Application for a Non-Material Amendment Following a Grant of Planning Permission

Town and Country Planning Act 1990
Proposed All remaining outstanding matters for plot 2 relating to DM/19/00978/OUT
At 2 Trinity Mews Durham DH1 5GG
For Mr Paul Doran
The above application received on 26 June 2023 was considered by the Council and it has been agreed that permission should be granted. I therefore enclose the appropriate approval certificate. If an application under the Building Regulations was also submitted, development must not commence until Building Regulations Approval has been received from the Building Control Division.

Minor changes to the Front Elevation (South West) window designs and size.

Title		Sheet 01	
Floor Plans		Revision	
A1 Scale	Drawn by	Date	Revision
1:50	PA	Sept 2023	B

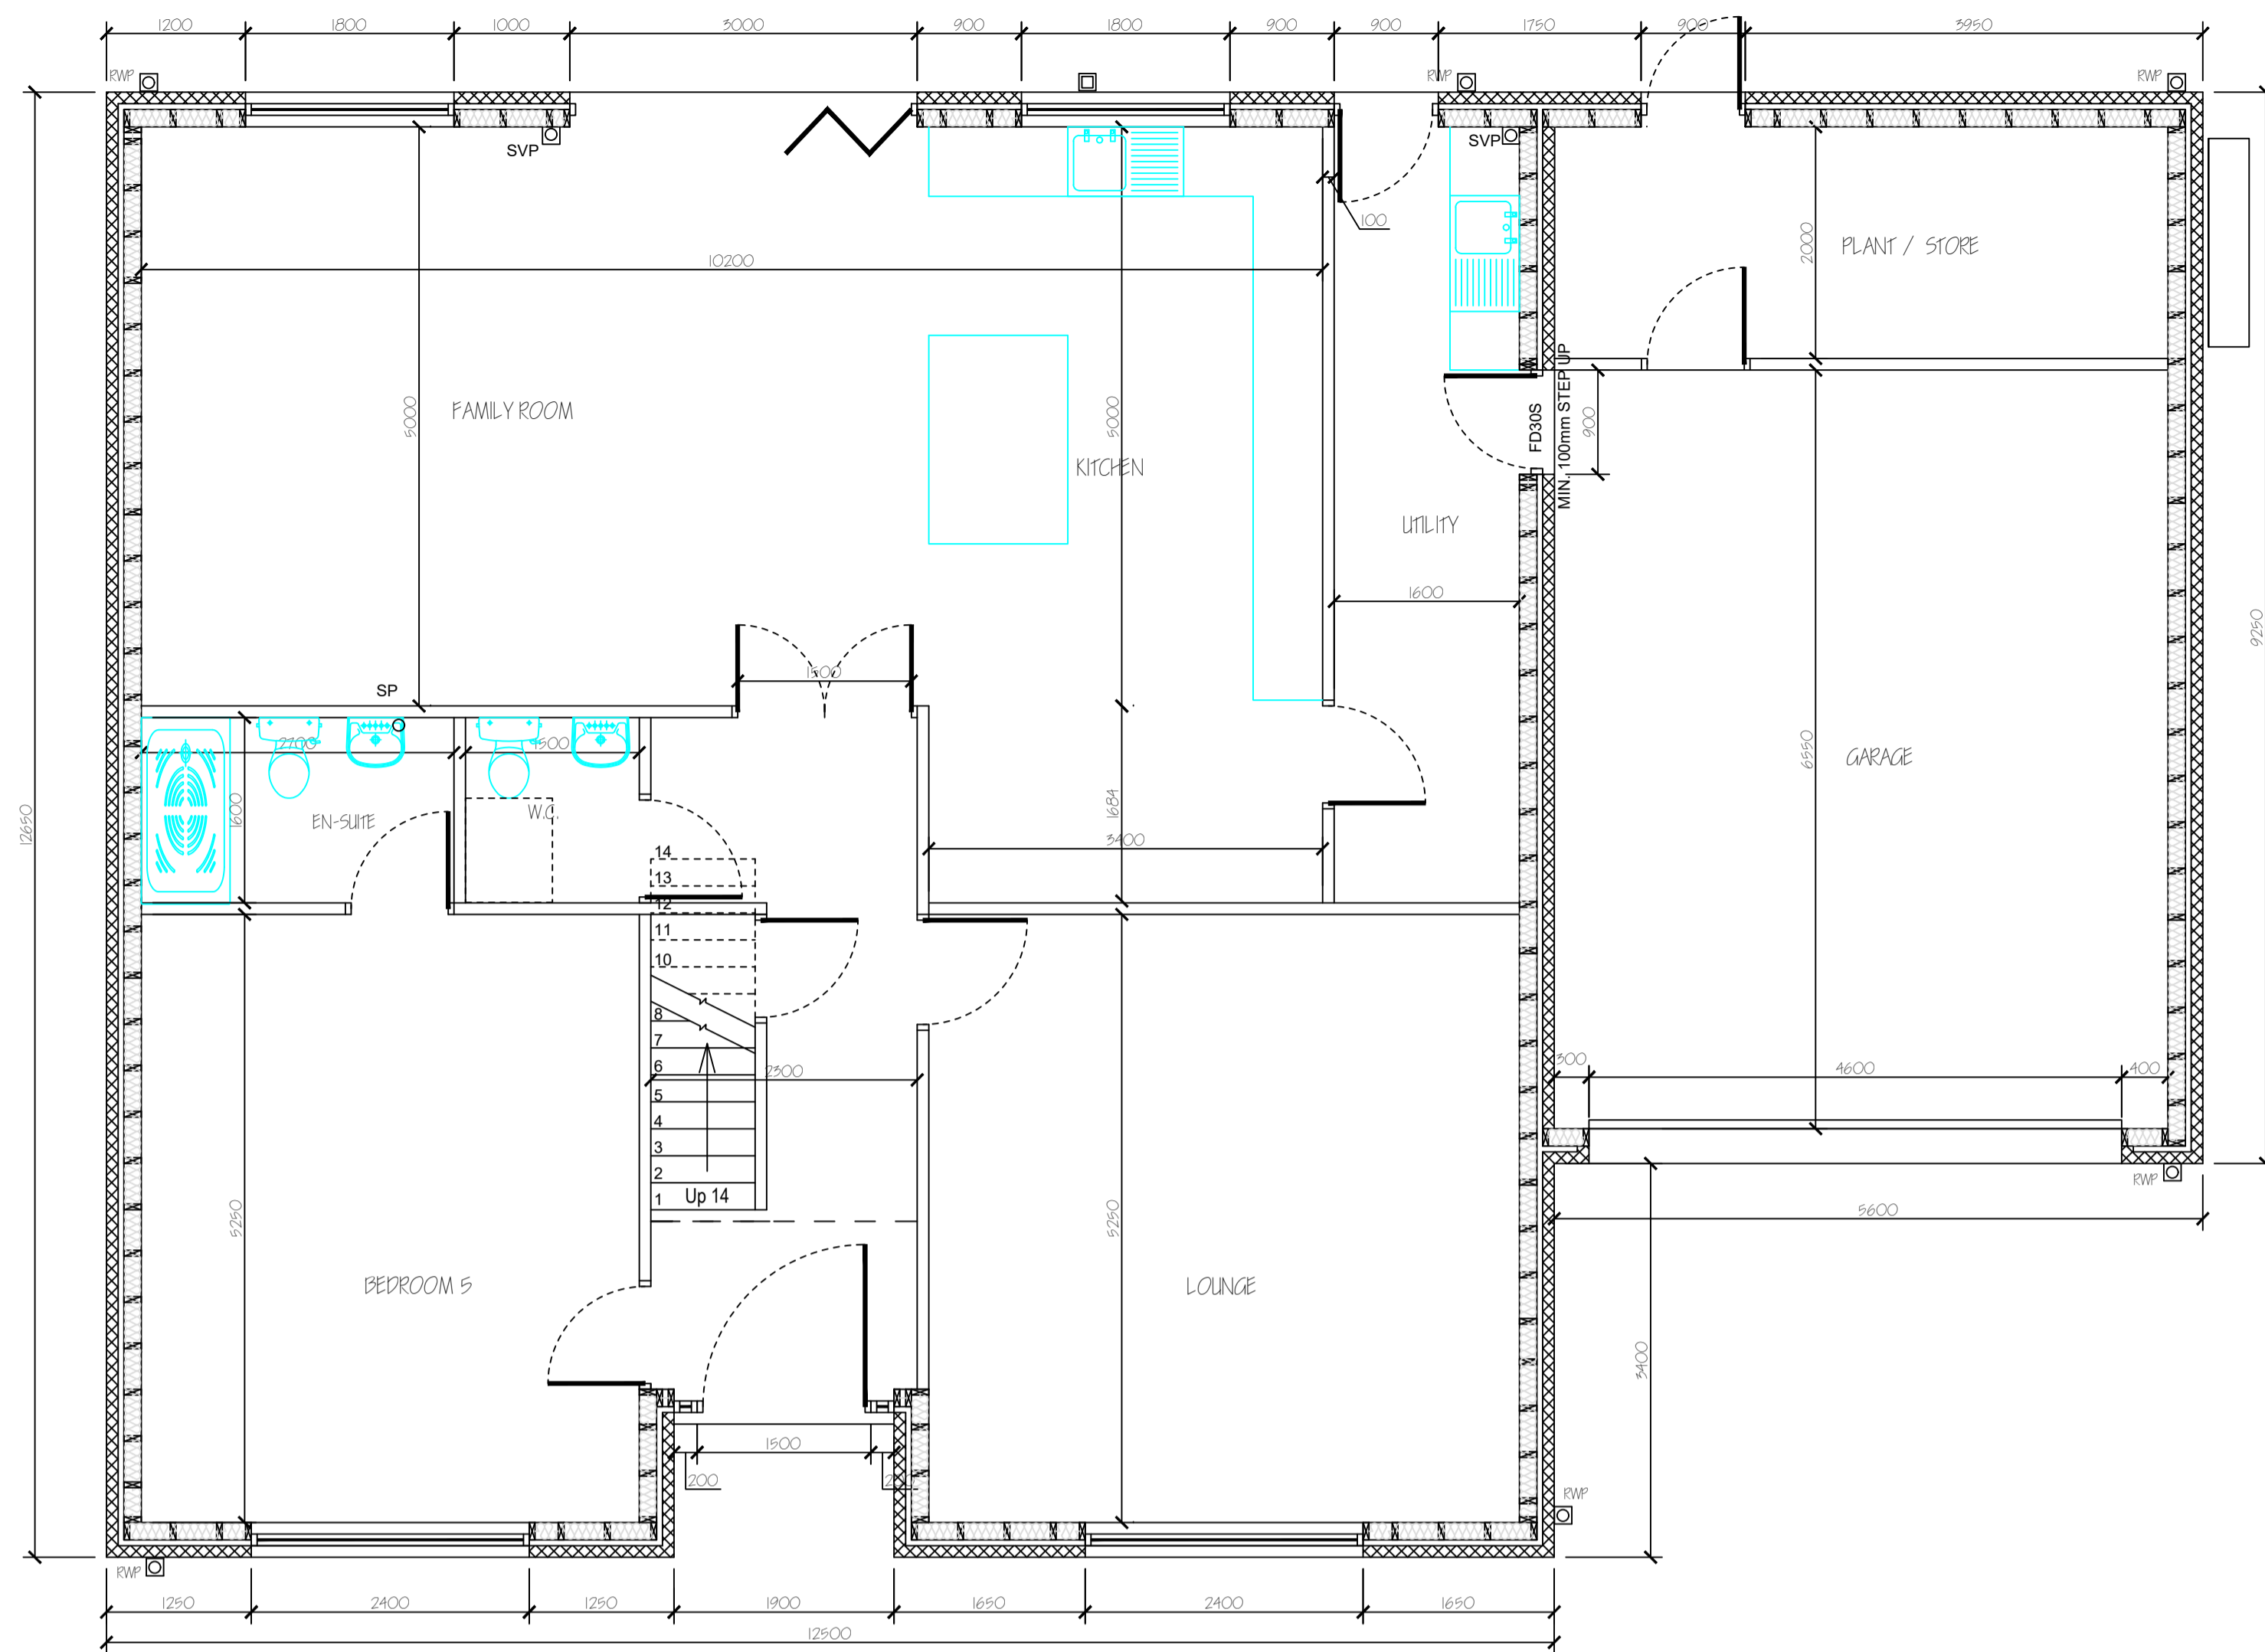
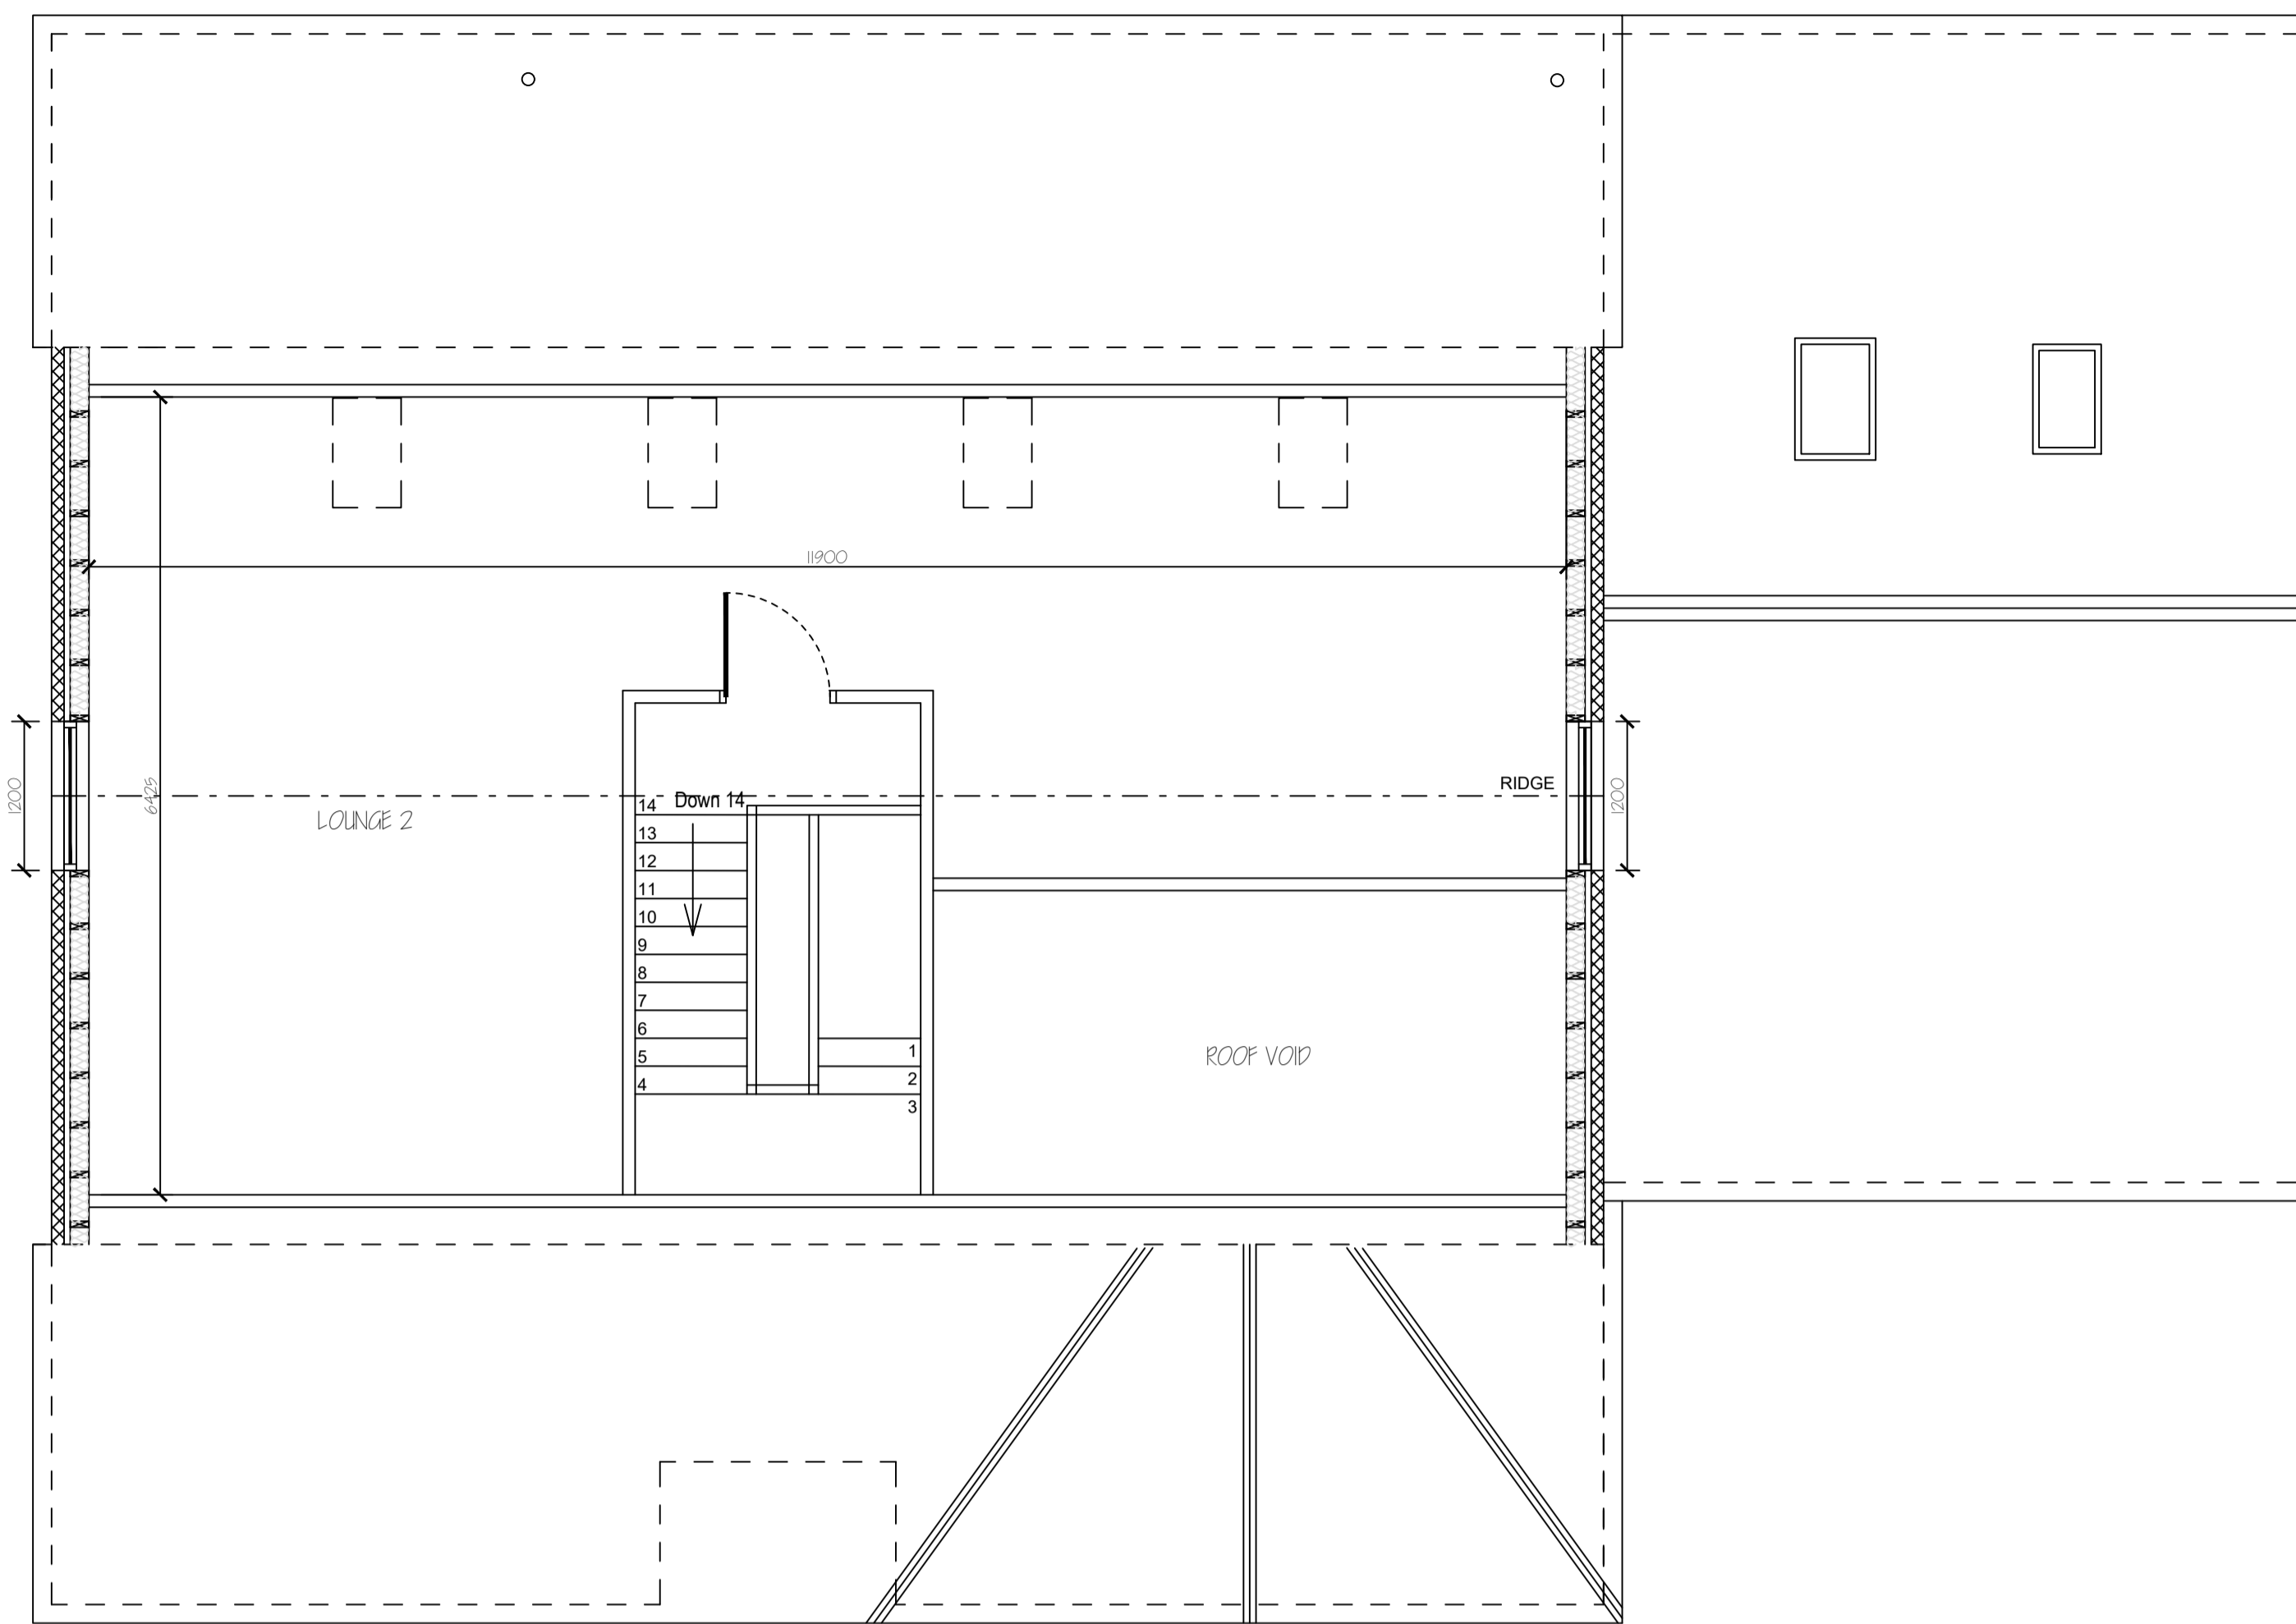
6. Remove 2 off uppermost windows on Gable Elevations, North West and South East facing.
7. Remove External rear door into Plant Room. External Rear door to Utility to remain.
